OUT21/3993

**200 Aldington Road Industrial Estate (SSD-10479)
RTS**

The following recommendations are provided by NRAR.

Figure 5 Proposed Concept Plan

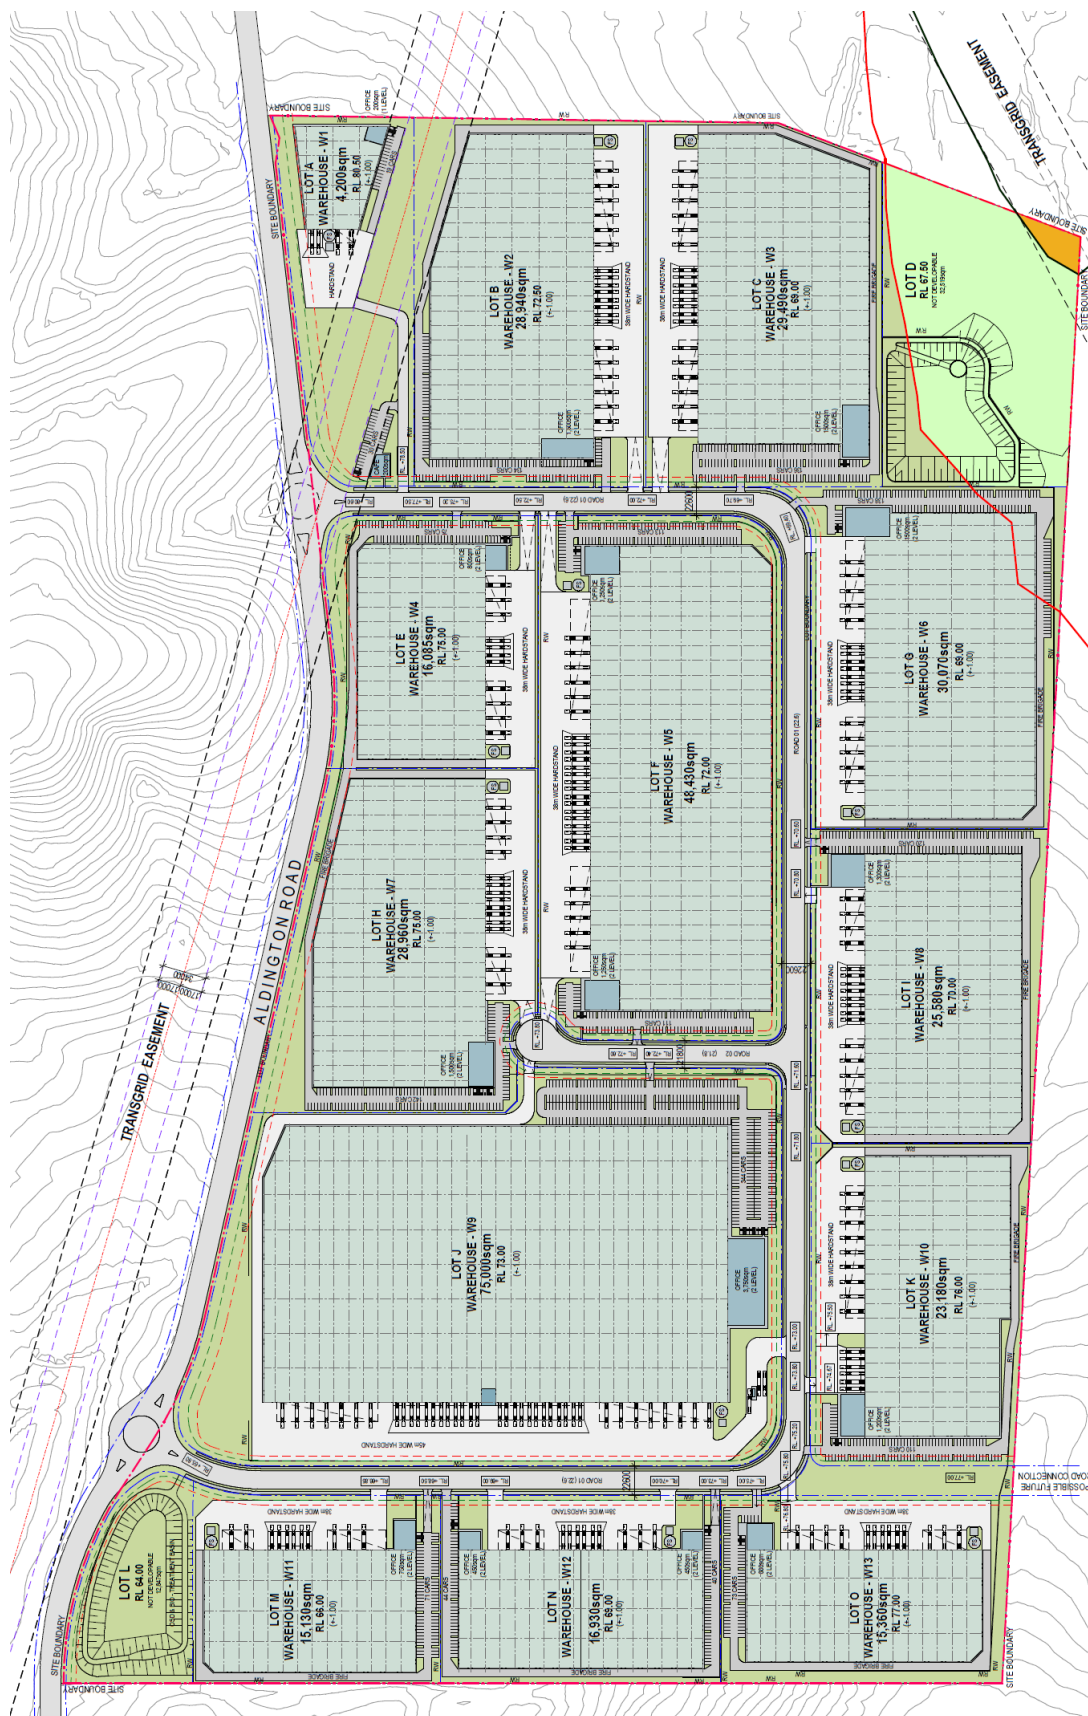
- The proponent should confirm offsetting has been incorporated into the VRZ.

In accordance with the NRAR Guidelines for Controlled Activities on Waterfront Land, offsetting for any Vegetated Riparian Zone (VRZ) encroachment is to occur along the same alignment of the watercourse. The concept plan includes a 5m wide VRZ along the basin retaining wall although does not show any offsetting along the same side of the watercourse.
